GRADING AND EROSION CONTROL PLAN

JUDGE ORR ROAD RV PARK AND STORAGE

EL PASO COUNTY, COLORADO

**JUDGE ORR ROAD RV PARK & STORAGE**  
**COLORADO SPRINGS, COLORADO**  
**DRAINAGE, GRADING & EROSION CONTROL PLAN**

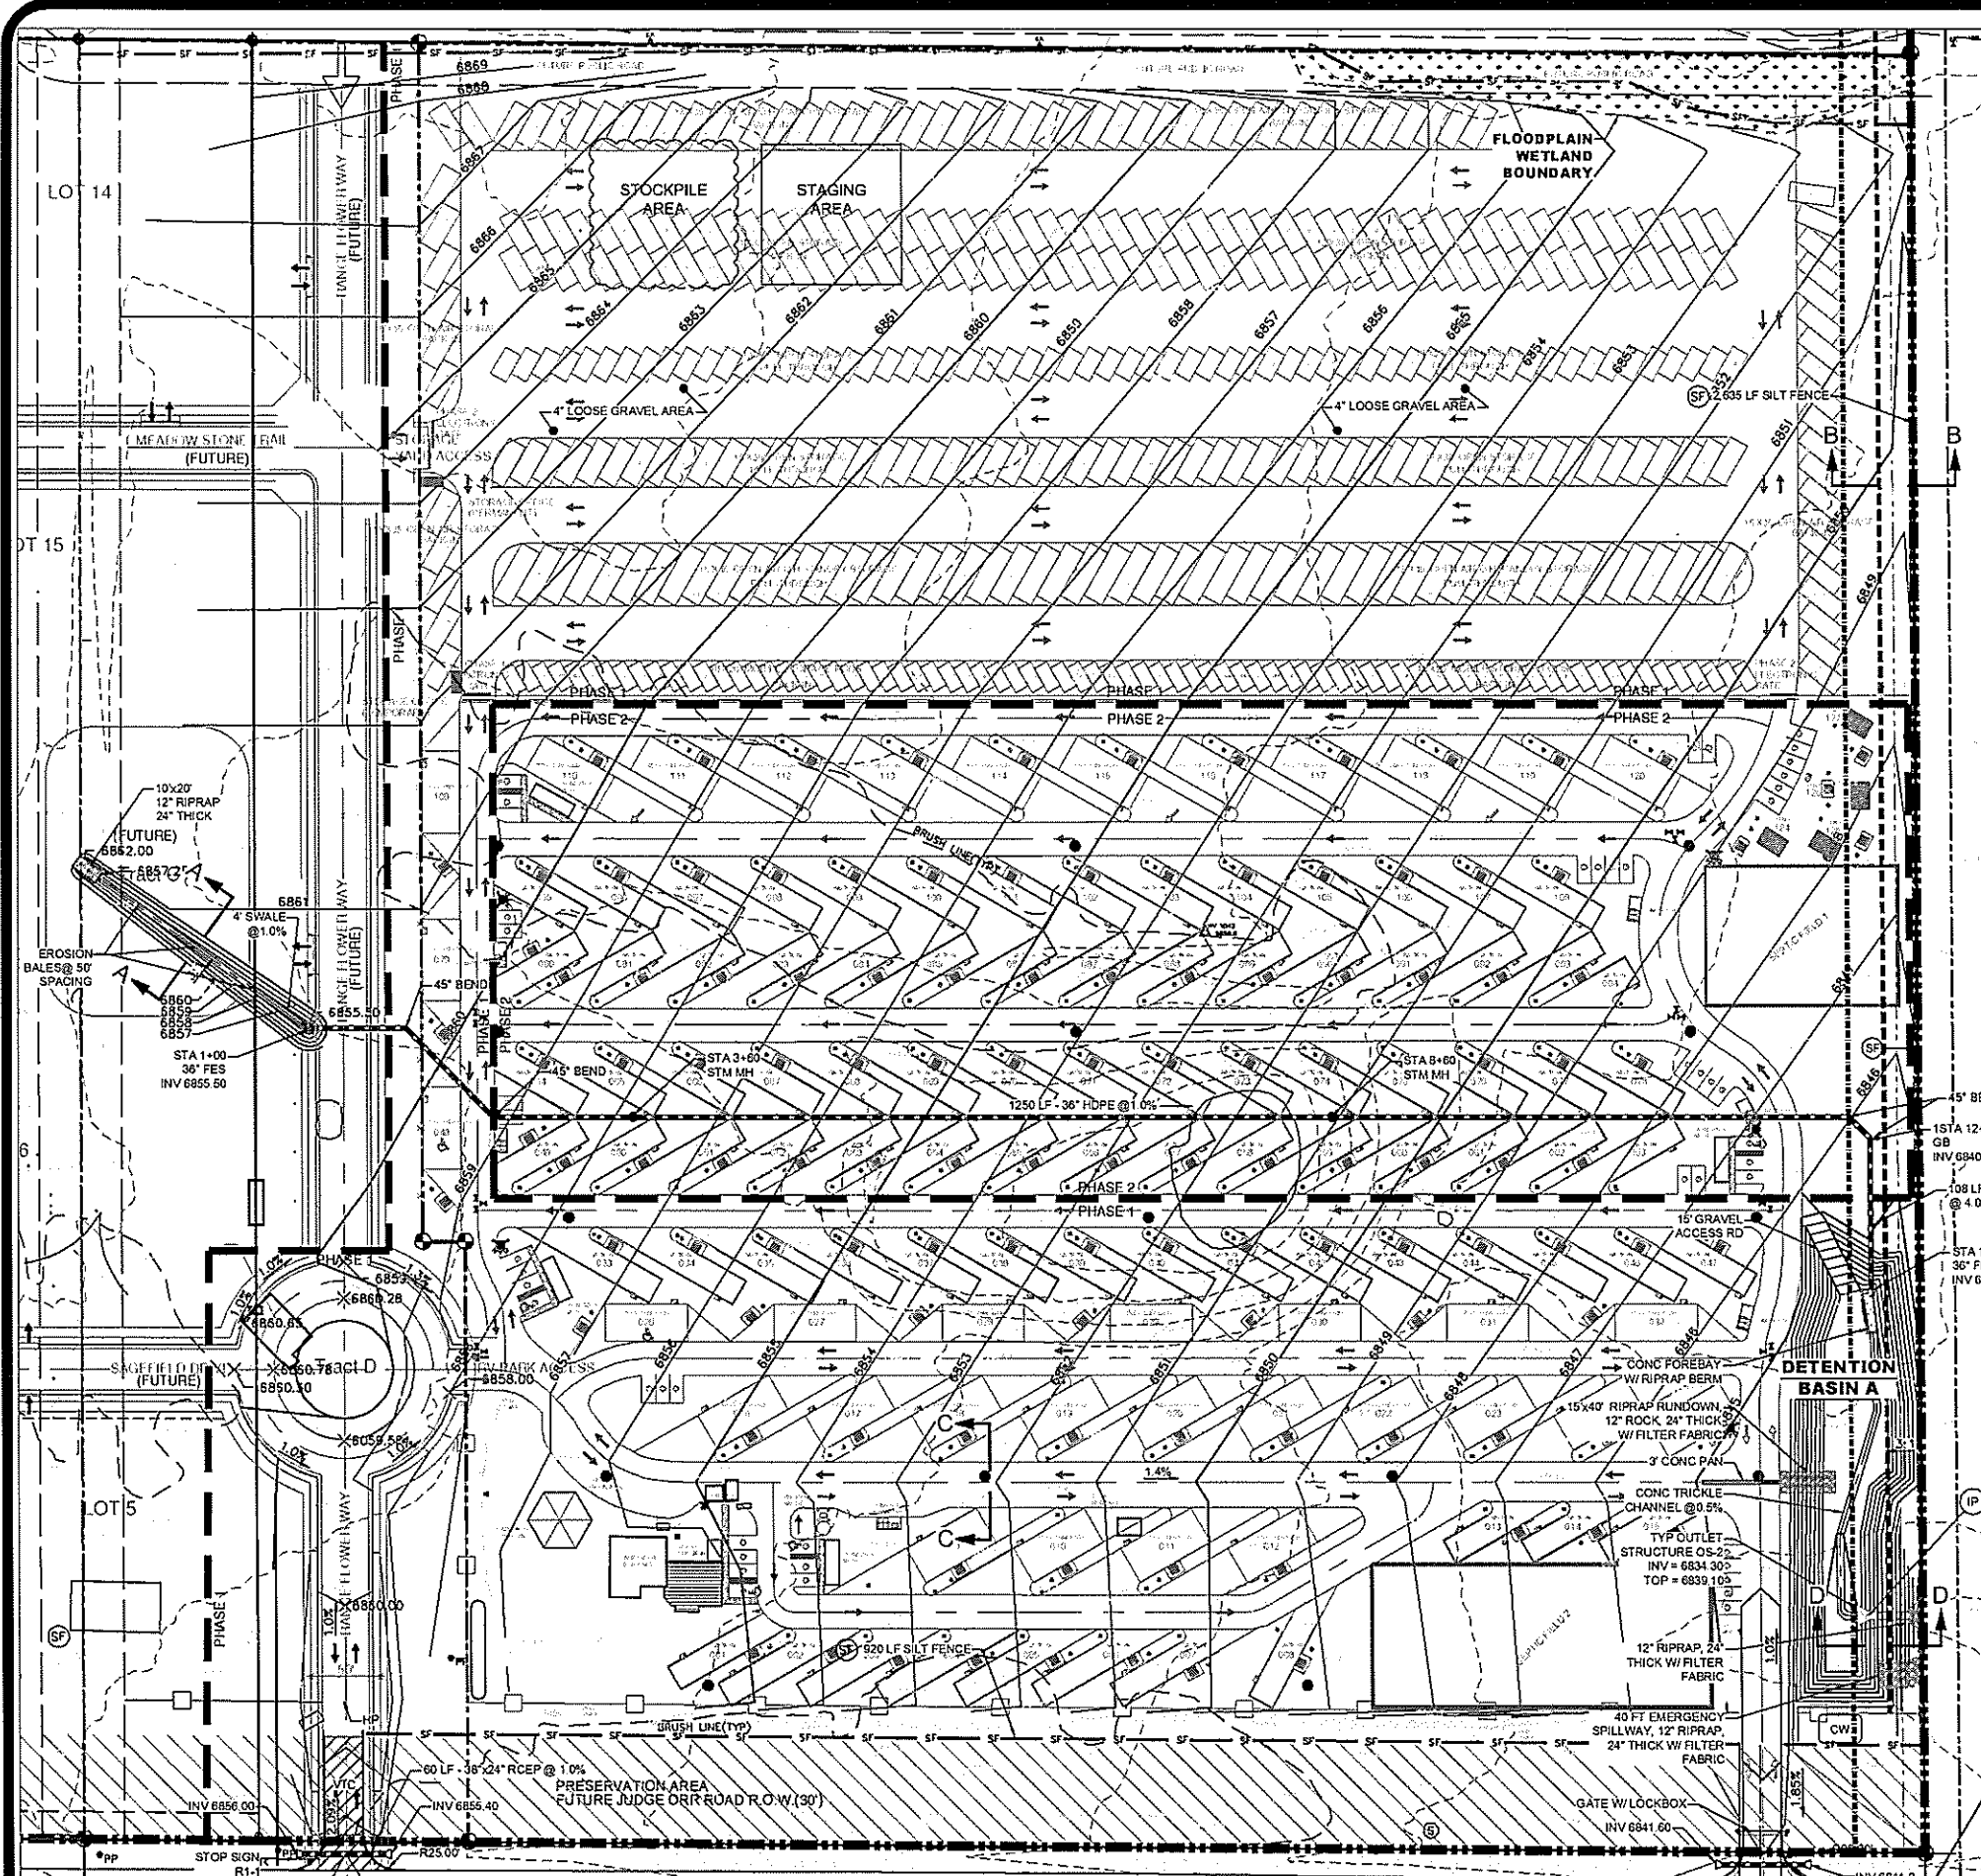
Callout the specific product to be used and in the appendix include the product specification that shows it is designed to handle the specific Froude number calculated. Typ. all

See drainage report comment to Pond 2 UD-Detention worksheet regarding the redlined areas.

Length does not match the measured length based on a 1"=60' scale. Update length and slope

Add (private) below the street name.

Silt Fence linework is not shown.

Provide a culvert plan & profile for both culverts. The top of pipe appears to be above ground. FG=6857.7 Top of Pipe = 6858.2

FIGURE OS-2 TYPICAL OUTLET STRUCTURE  
FOR FULL SPECTRUM DETENTION  
**OUTLET STRUCTURES DETAILS**  
NOT TO SCALE

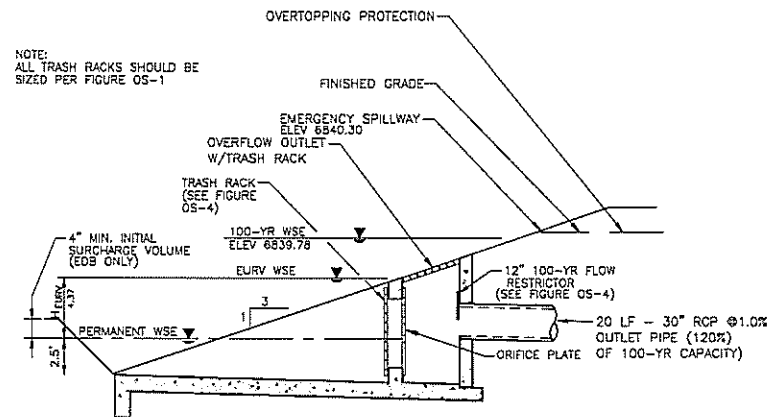
Drainage report calls for a larger diameter. Revise. Height between orifice does not match the outlet structure design in the drainage report. Replace the H/3 with the actual elevation of each orifice centroid. The 3.76 height does not match Fig OS-5 which notes 4.37

See the comment on the FDR UD-Detention worksheet. Design is likely to be revised. Will review with the resubmittal.
